**Consultation Response from KC Landscape**

<b>Application No:</b>	2024/91316
<b>Proposed Development:</b>	Conversion of existing dwelling and outbuilding to create 6 apartments and erection of 17 dwellings
<b>Location:</b>	Clough House, 236, Leeds Road, Birstall, Batley, WF17 0HW
<b>Applicant/Agent:</b>	Acumen Designers & Architects Ltd
<b>Planning Officer</b>	Ellie Thornhill
<b>Date Responded:</b>	12.08.2024
<b>Responding Officer:</b>	Landscape
<b>Responding Ref:</b>	NN30

Plans considered/reviewed: Proposed site tree & boundary plan rev B dwg (100) 07 B  
 Proposed site layout & 3D (100)06 rev A  
 House & Outbuilding plans  
 Planning statement

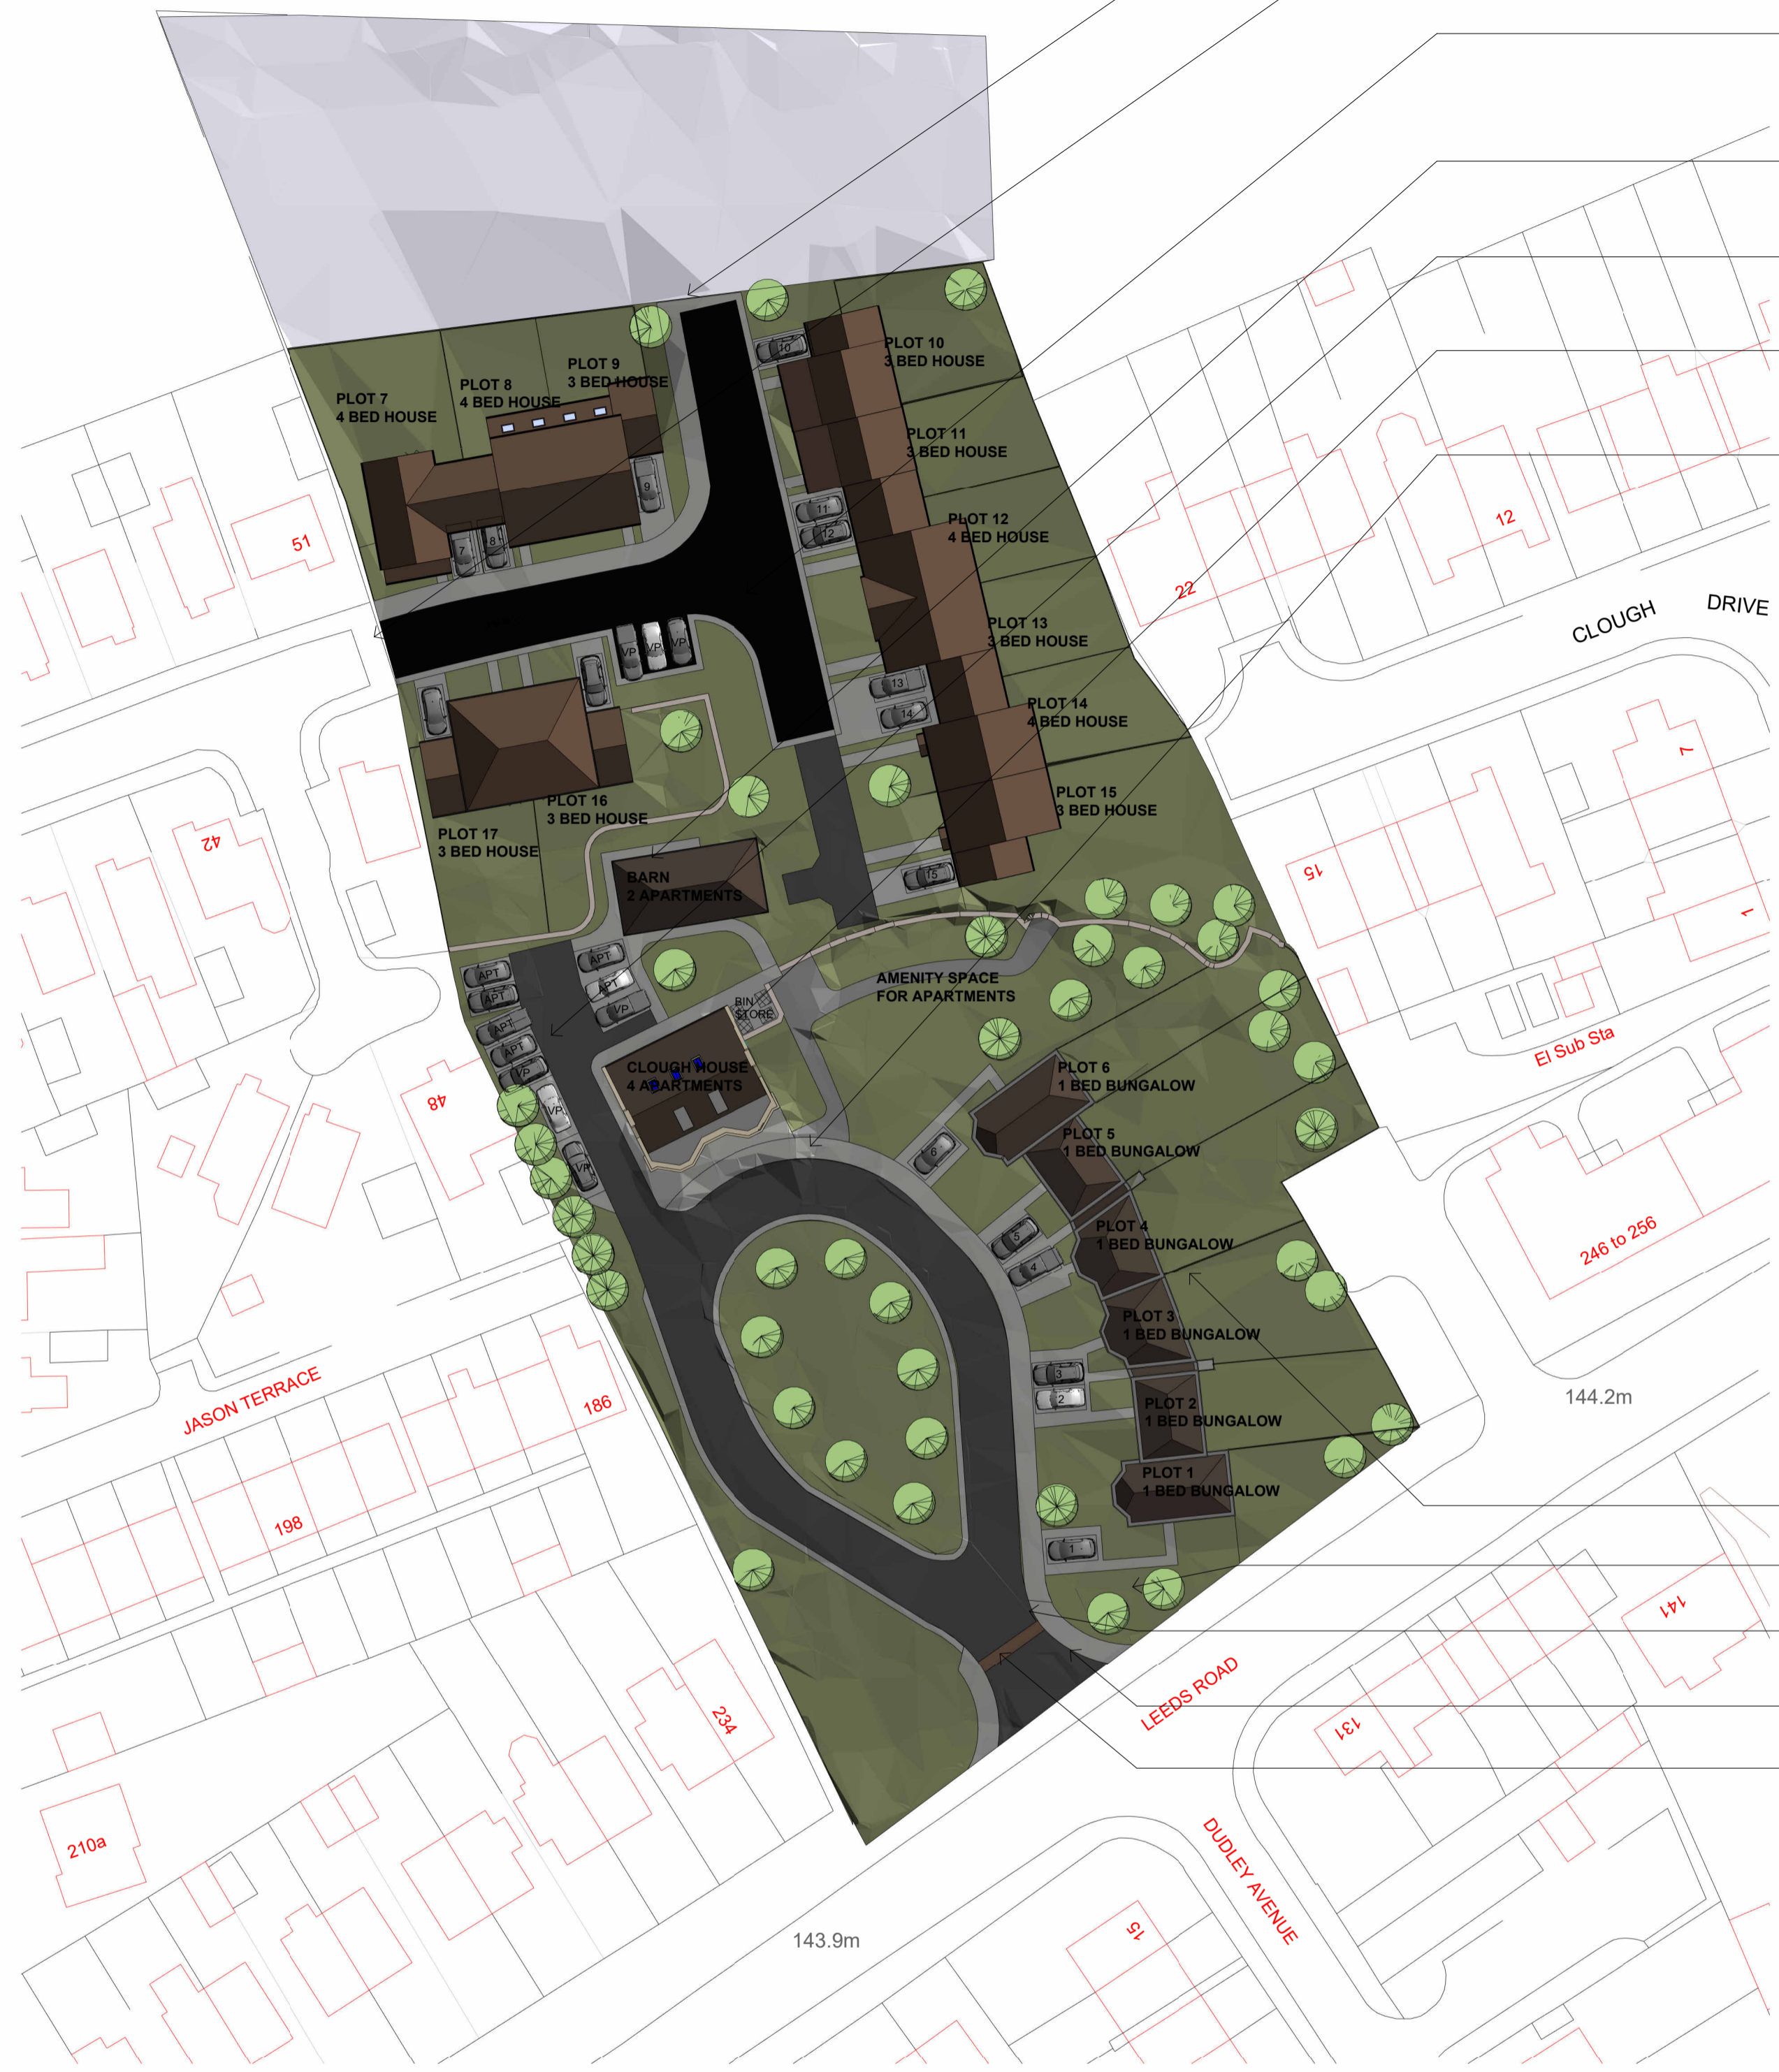
5. The plan is very indicative in landscape terms, therefore difficult to provide meaningful comments, however, some greenspace on site is shown and is welcome, however, consider access and purpose of the spaces being created. Will the spaces provided meet the needs of the widest possible range of users, be easily accessible and enjoyed

by all people, regardless of visual, physical and cognitive ability, mobility, background or age. Are some of the areas shaded green more likely highways verges or buffer and screen planting?

9. The landscaping is indicative but if the landscaping scheme can be secured by condition then it should also be to prevent the proposed quality and number of trees from being eroded in any subsequent applications.

15. The scheme does not provide sufficient street tree planting for the development which would be preferred. Trees in rear or private gardens cannot provide the same public amenity and tend to be removed before they reach a size that allows them to contribute to the setting of the development. The proposed site plan refers to the native tree planting along frontage to frame view of the main house, however they look to screen it when entering the site.

17. Concern that the bin presentation point for the apartments will restrict access for the public to the POS path

24. **Access:** Proposed paths either linking to or from open space should not connect onto private drives or parking spaces, as this will cause access issues and conflict for future residents.

- Introduce pathways/access routes, bins and benches into amenity greenspaces.
- Please show drainage infrastructure on the landscaping plans, to demonstrate no conflict between trees and drainage.
- **Landscape** – it would be prudent, given the setting of this scheme, to secure early submission of Landscape details for both hard and soft landscaping, together with a Management Plan and conditions suggested A, B, C and D below.
- S106 should include the landscape scheme with reference to all Drawing nos and the POS typologies plan being annexed to it, together with the text “together with such amendments as the Council may reasonably require”.
